CITY OF ALBUQUERQUE

December 6, 2019

Re: Zia Napa Autocare
5312 Phoenix Avenue
Traffic Circulation Layout
Engineer's/Architect's Stamp 11-25-2019

SITE PLAN / TRAFFIC CIRCULATION LAYOUT

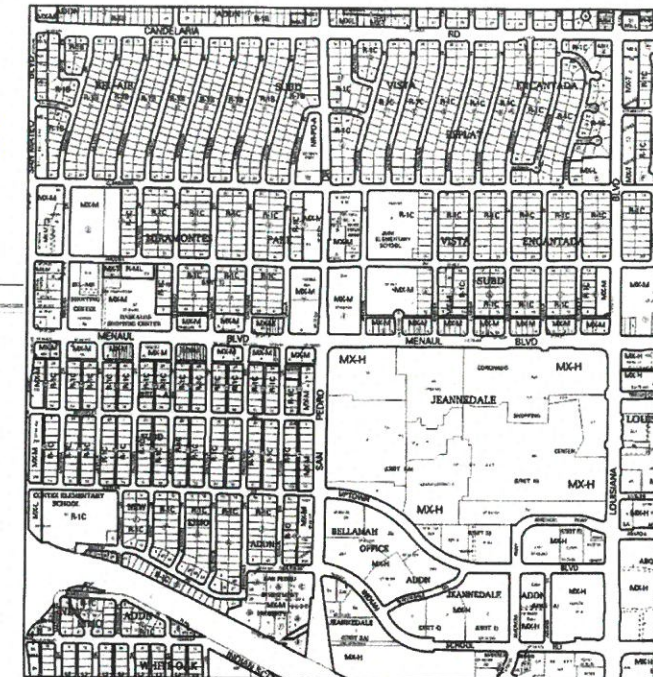
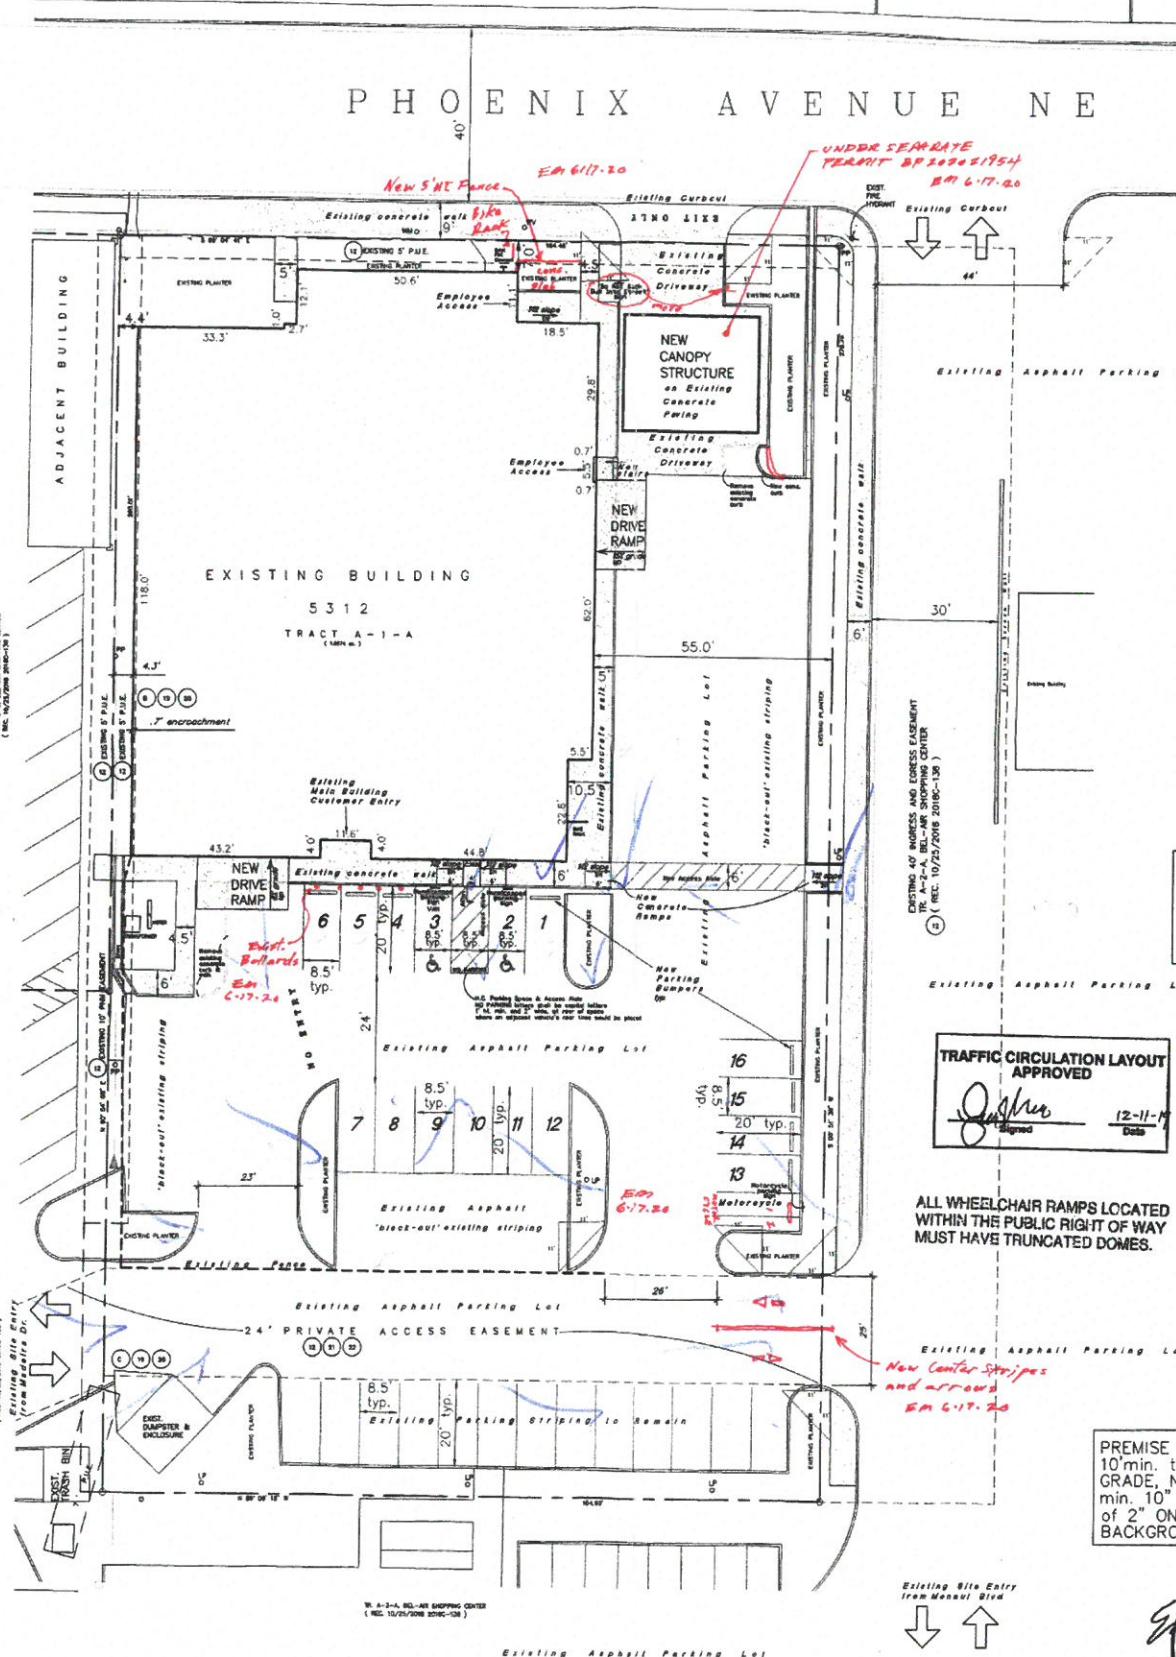
1. Label existing sidewalk widths for Phoenix Avenue and for the existing access easement to the east of the site. Also label width of existing on-site walkways.

2. Label width of handicapped spaces and van accessible aisle. The van accessible aisle shall be at least 8 feet in width.
3. Label existing and new parking bumpers and curb ramps, as applicable, and show doorway entrances.

4. The ADA accessible parking sign must have the required language per 66-7-352.4C NMSA 1978 **"Violators Are Subject to a Fine and/or Towing."** Please call out on detail.

5. ADA access shall be provided from the handicapped spaces to Phoenix Avenue.
6. What are the slopes of the new drive ramps? Label these. Provide ADA access across the new drive ramp on the east side of the building with a 4-foot wide 2% maximum cross-slope that matches with the sidewalk on either side of the drive ramp.

7. Show the clear sight triangle for the existing entrances to the site, and add the following note to the plan: "Landscaping and signage will not interfere with clear sight requirements. Therefore, signs, walls, trees, and shrubbery between 3 and 8 feet tall (as measured from the gutter pan) will not be acceptable in the clear sight triangle."
